06 June 2013

**Ref Eleven Self Contained Flats - Summerley Corner (South Site),
Limmer Lane, Bognor Regis. - Proposed Non Material Amendment
Application to LPA Ref. FP/189/09.**

GROUND FLOOR PLAN

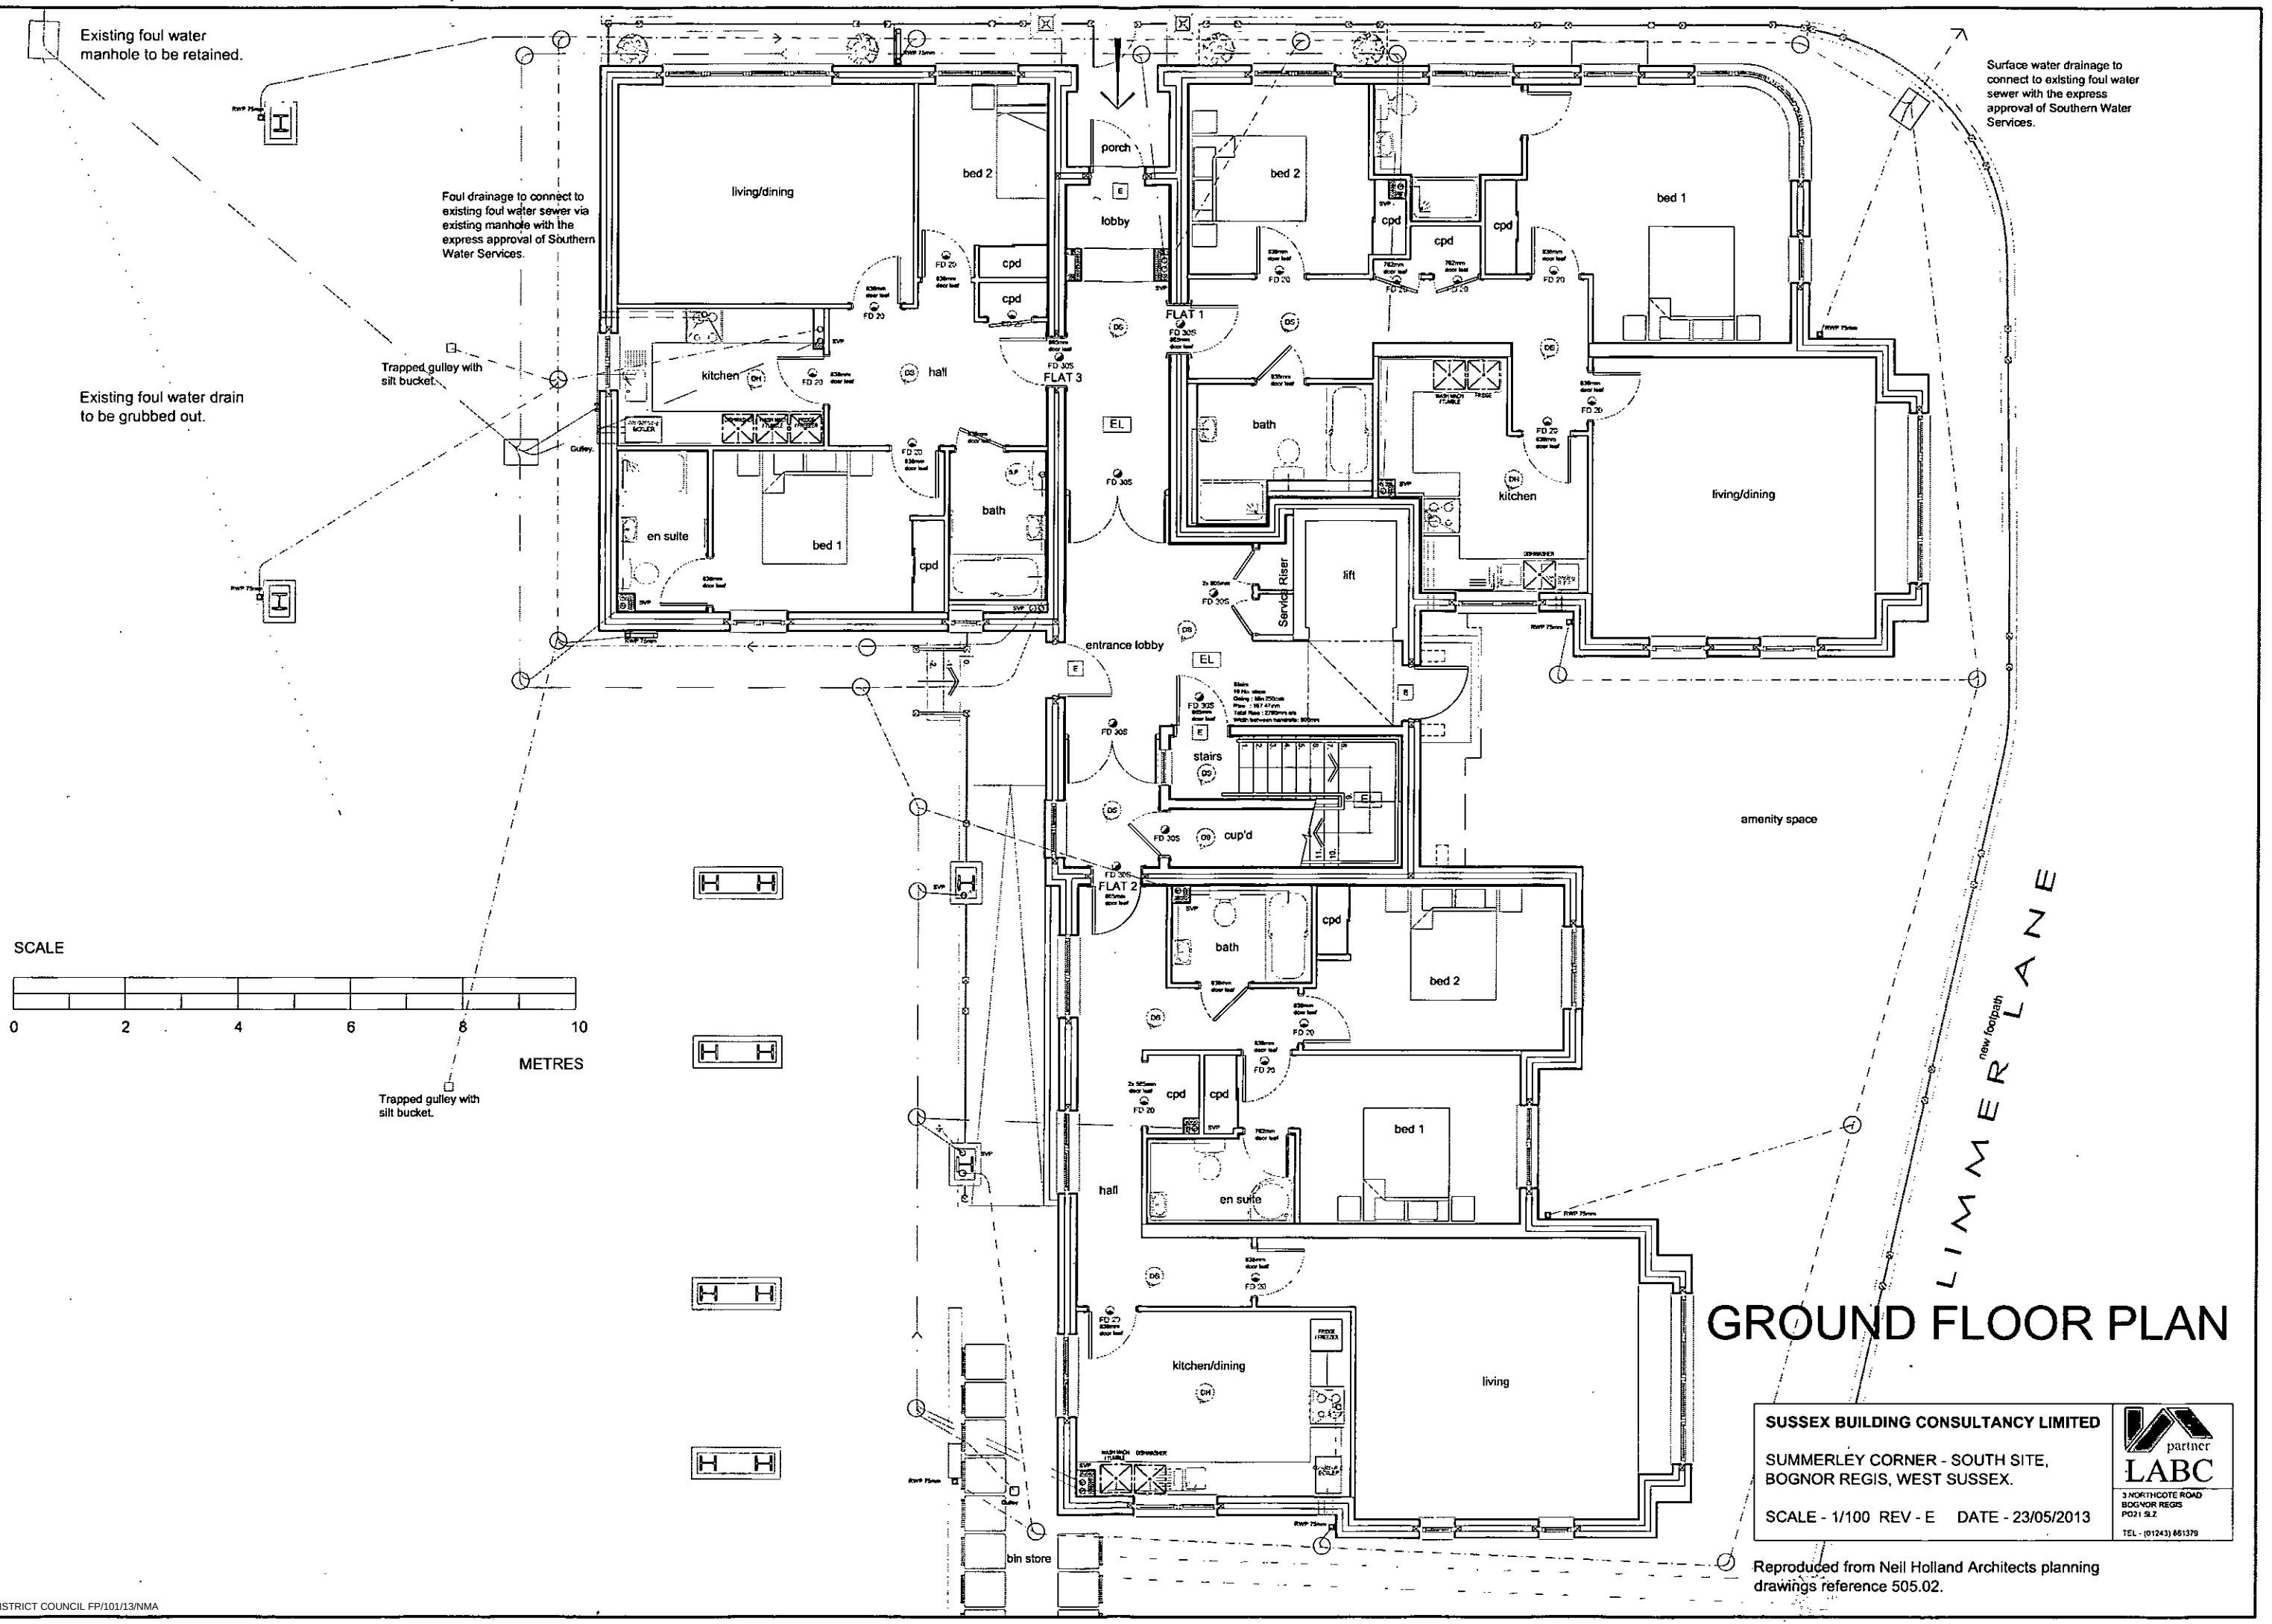
2. Removal of the proposed chimney stacks that are not required as no secondary heating is proposed to the apartments. ✓
3. Alterations required for structural reasons - the lowering of the undercoft to house the depth of beams necessary, the addition of two new supporting piers and the small movement of other piers to reduce the cantilever of the upper floors. ✓

7. Although not specifically mentioned on the plans - the inferred use of copper and lead roofing may be substituted with a GRP alternative to help keep costs down. ✓
8. Amended parking and building rear access layout to accommodate the the new columns and positions. ✓

FIRST FLOOR PLAN

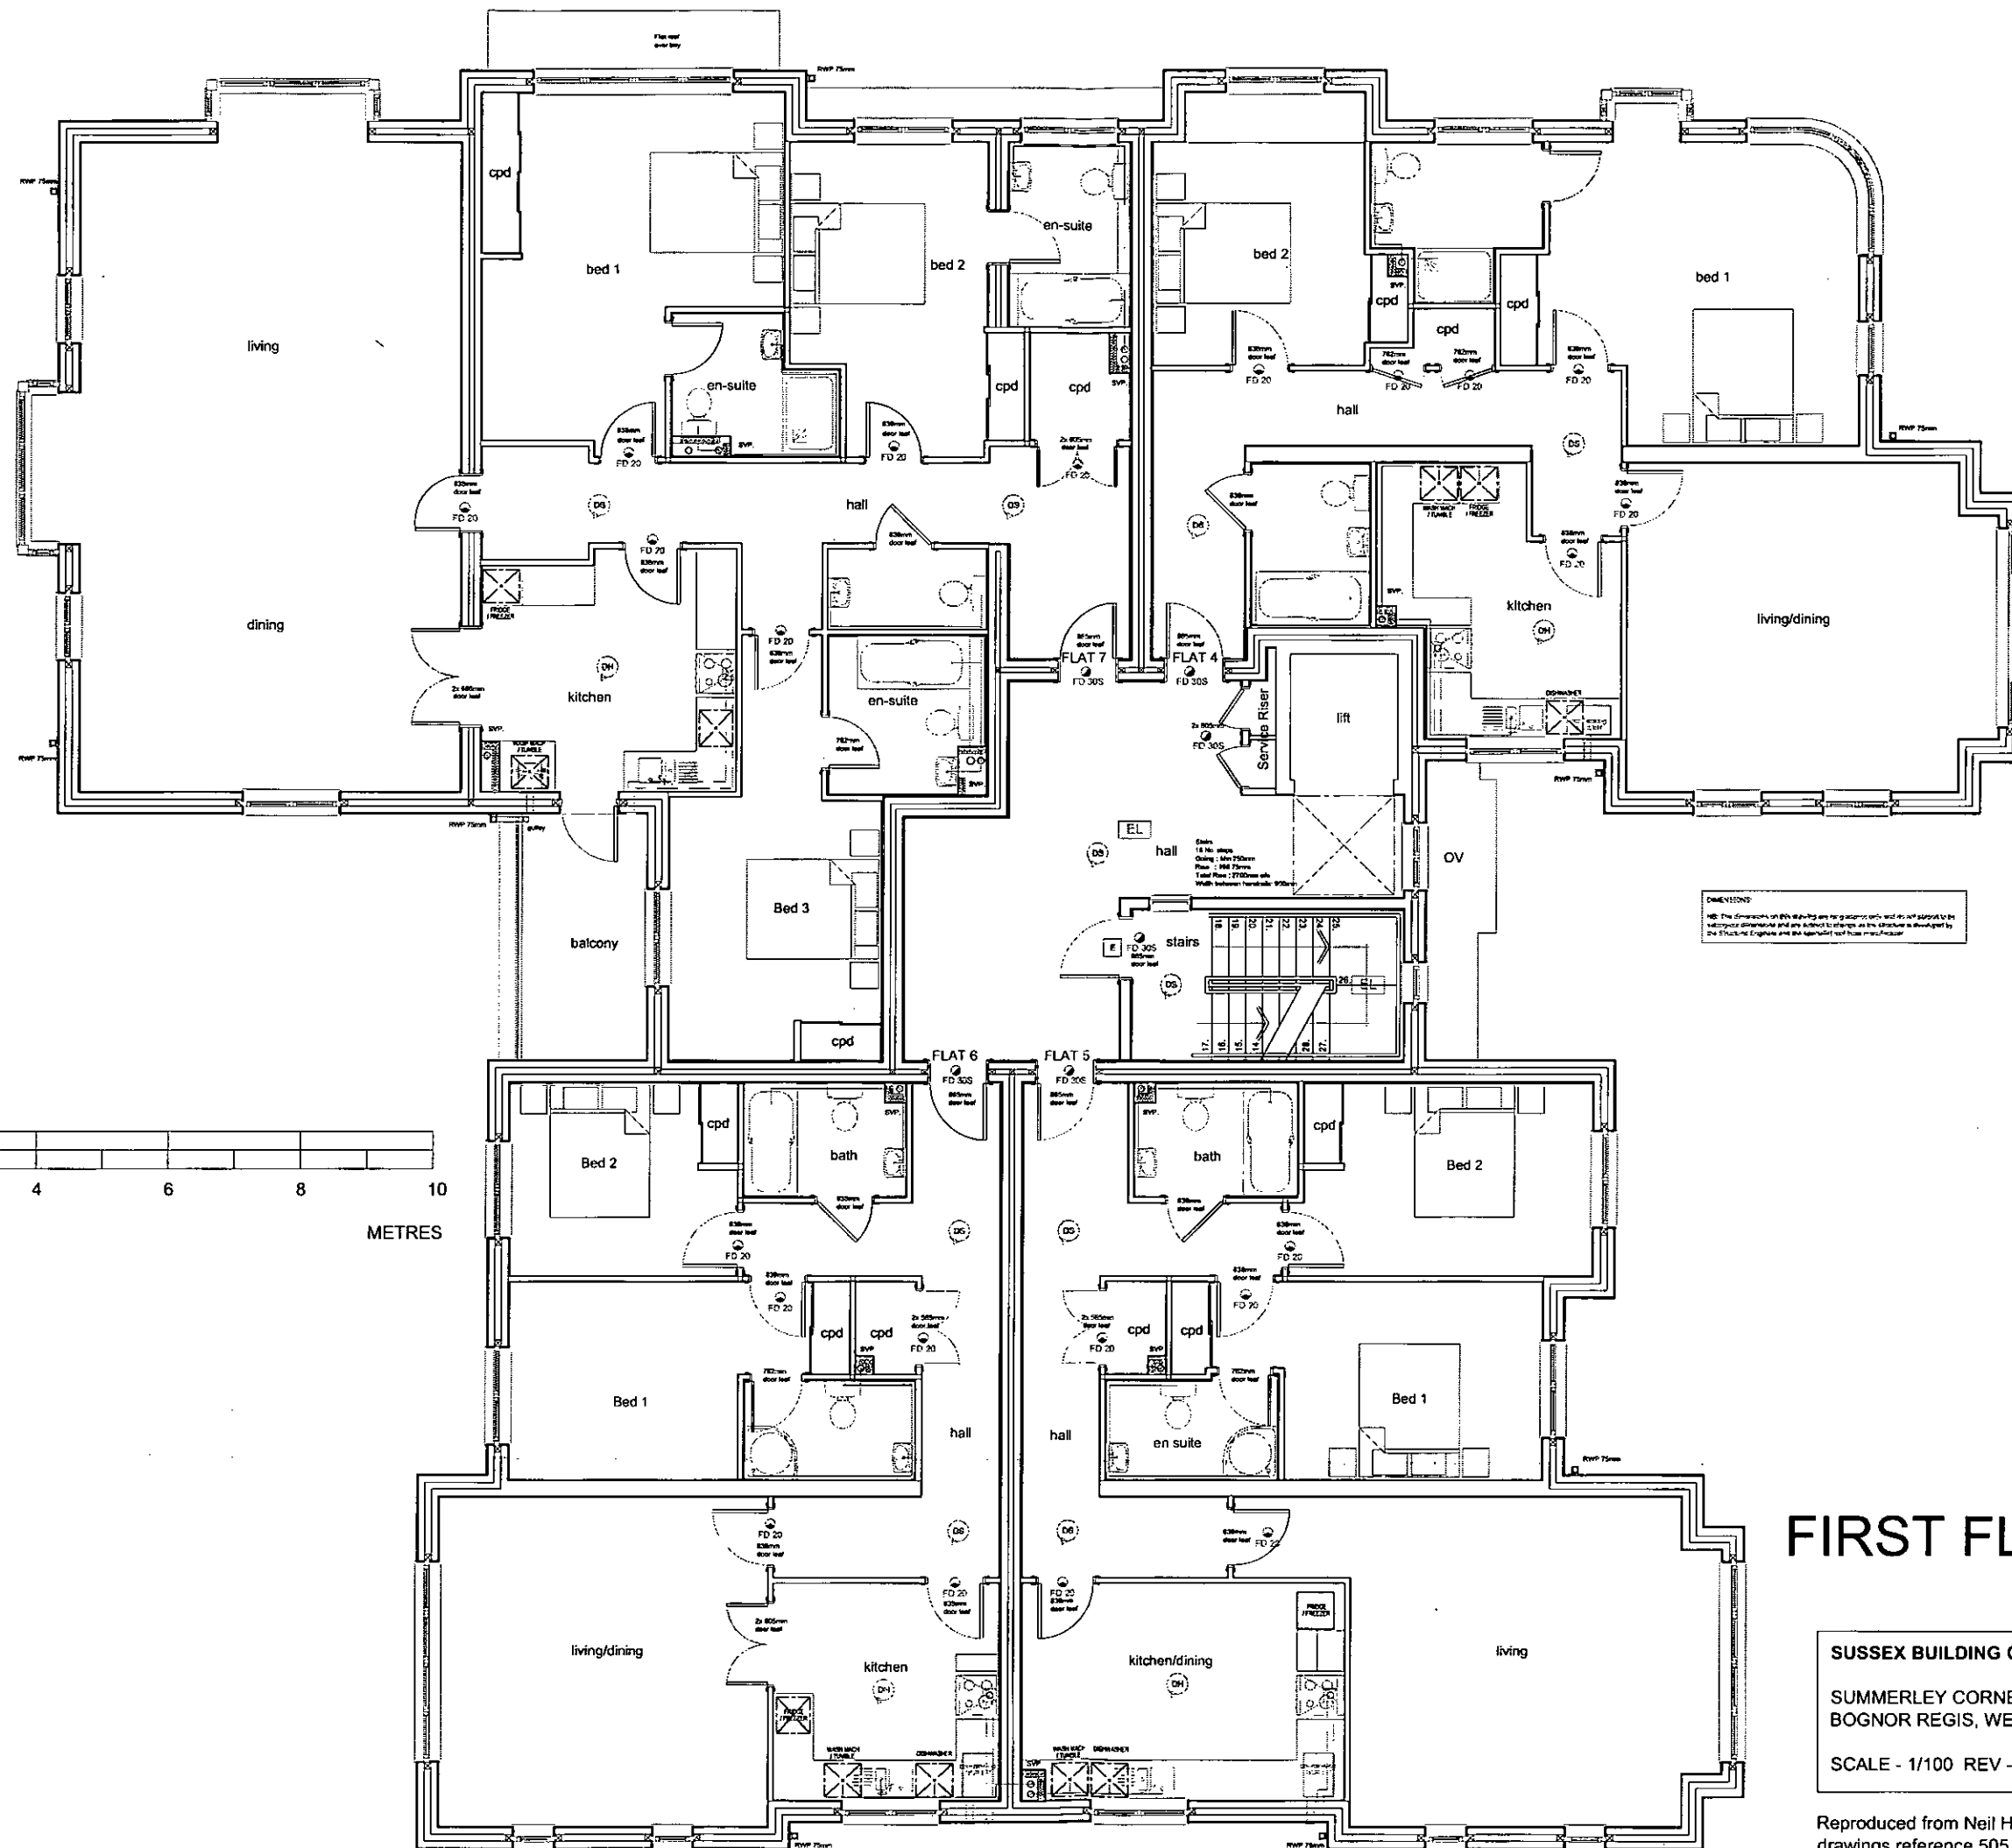
1. Raising the eaves and corresponding ridge levels by approximately 175 mm - this is to allow for the requisite upper floor constructions for sound insulation reasons and a reasonable internal floor to ceiling height of 2.4 metres.
